Recommendation Report for Works to Tree(s) on trees subject to a Tree Preservation Order (TPO)

REF NO: FP/196/19/T

LOCATION: 33 Roundle Avenue
Felpham
PO22 8LL

PROPOSAL: Crown lift by 4m on circumference of tree to allow 6m over road to 1 No. Ash tree.

REF 1

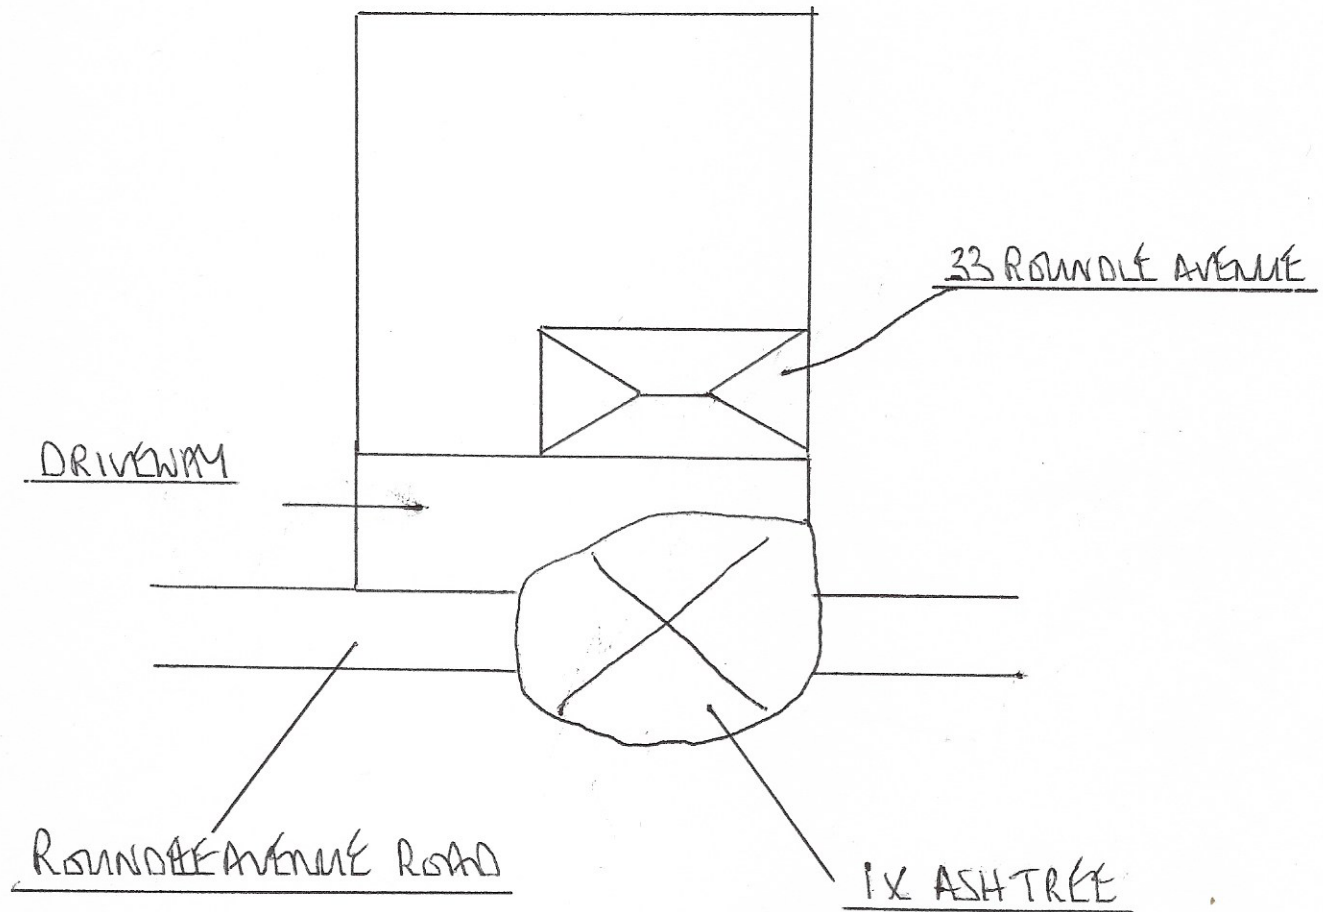
This tree had been 'topped' at around 5m height but has grown-on well and presents an attractive crown profile. Outwardly and from a distance it appears to be in a fine physiological state and structurally sound.

·The applicant seeks to remove/reduce low branches to achieve no more than 4metres overhead clearance on all aspects; 6metres overhead clearance directly above the carriageway.

·The work proposed is justified on arboricultural grounds as it seeks to strike a balance between the tree's influence and potential impact on surrounding residential property/highway users and the need to retain trees with dignity by having respect for natural tree form.

·If the work is undertaken to a good standard, then it is unlikely to have an adverse effect on the tree's long-term vitality and visual amenity.

·Where whole branches are to be removed and final cuts made close to the trunk or branch union they are to be made as shown in Figure 2 of BS3998:2010

·Where branches are to be shortened back the final cuts are to be made at the correct angle shown in BS3998:2010 and adjacent to a live bud or lateral.
